## Appendix C

### Project Amendments

**Re: Walla Walla Solar Farm Mod 2 (SSD 9874 Mod 2)  
Project Amendments**

This Amendment Report accompanies the Response to Submissions (RTS) for Walla Walla Solar Farm Modification 2.

APPENDIX 5: HEAVY VEHICLES REQUIRING ESCORT AND HEAVY VEHICLE ACCESS ROUTE RESTRICTIONS

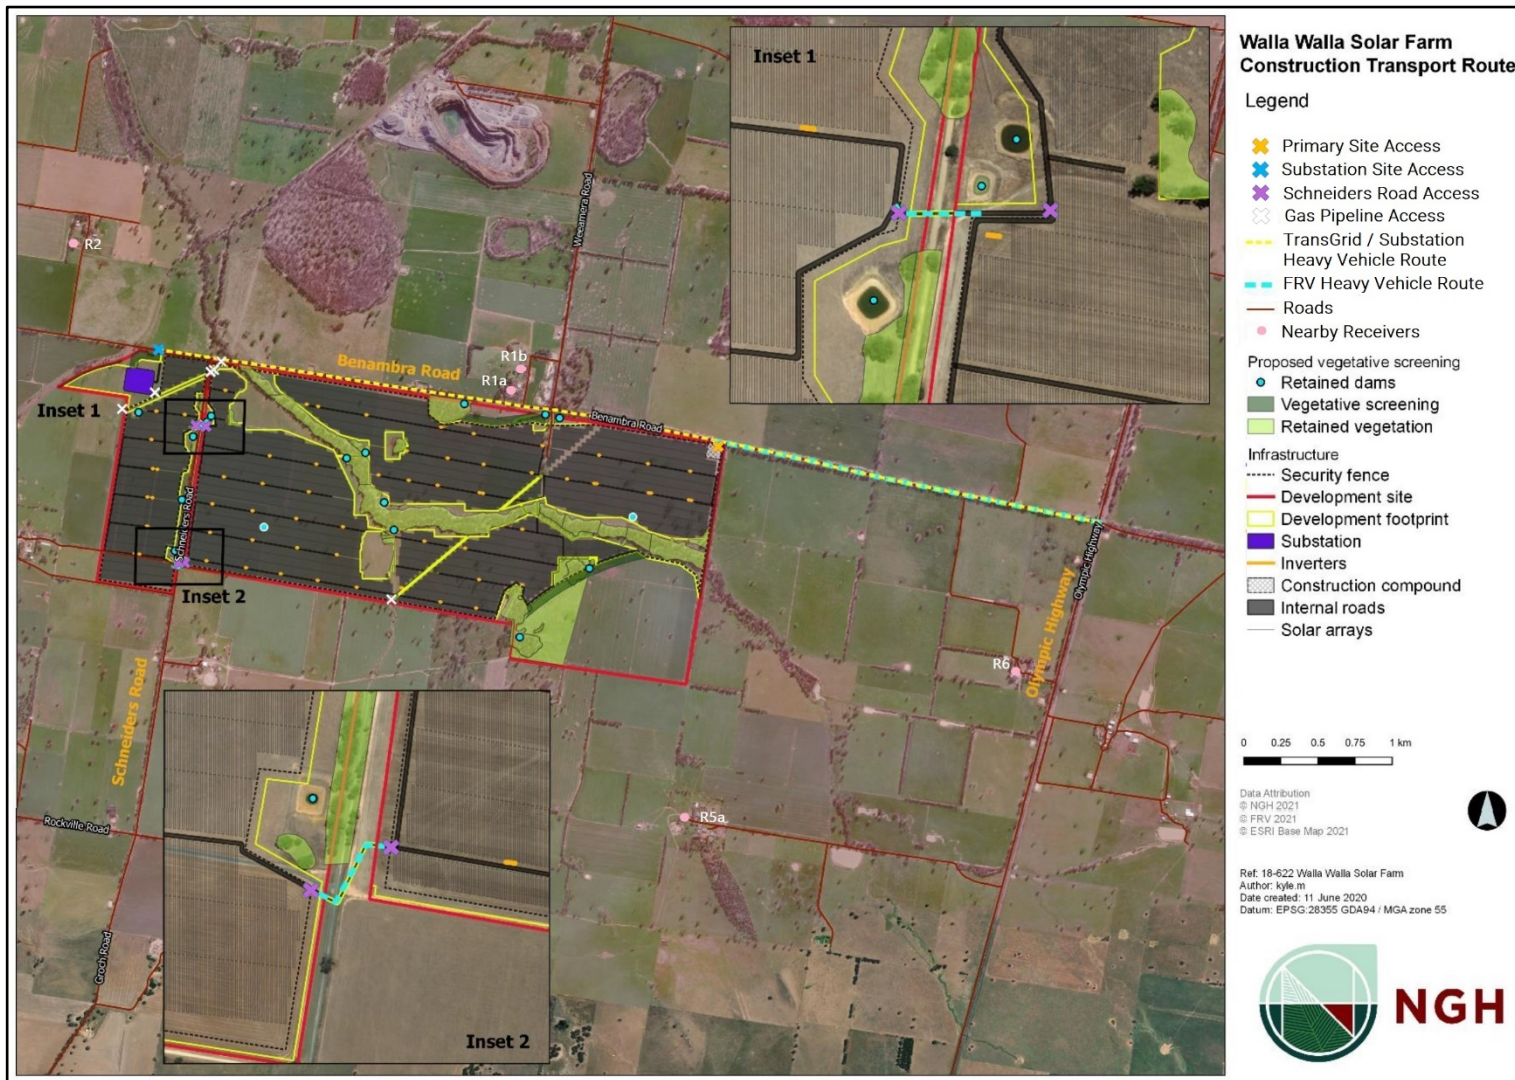
The conditions of consent presently allow up to ten heavy vehicles access the Substation Access Point, as shown in Figure 1 throughout the construction period. This was previously required to allow Transgrid to commence construction of the project's substation whilst the internal roads were being constructed.

In response to concerns from members of the community and Council, FRV has committed to relinquishing its approval for heavy vehicles to use the substation access during construction. This means that all heavy vehicles throughout construction would use the Primary Site Access and internal road network.

Over-dimensional vehicles would still be required to use the Substation Access as the internal road network and, in particular, the creek crossing would not permit safe movement of these vehicles within the site. FRV notes that the original DA conditions of consent permitted over-dimensional vehicles to use the substation access.

| Condition                | Description  | Proposed Amendment to Conditions of Consent   |
|--------------------------|--|---|
| APPENDIX 5               | OVER-DIMENSIONAL AND HEAVY VEHICLE ACCESS ROUTE RESTRICTIONS | Replace the existing figure with Figure 1 of this report  |
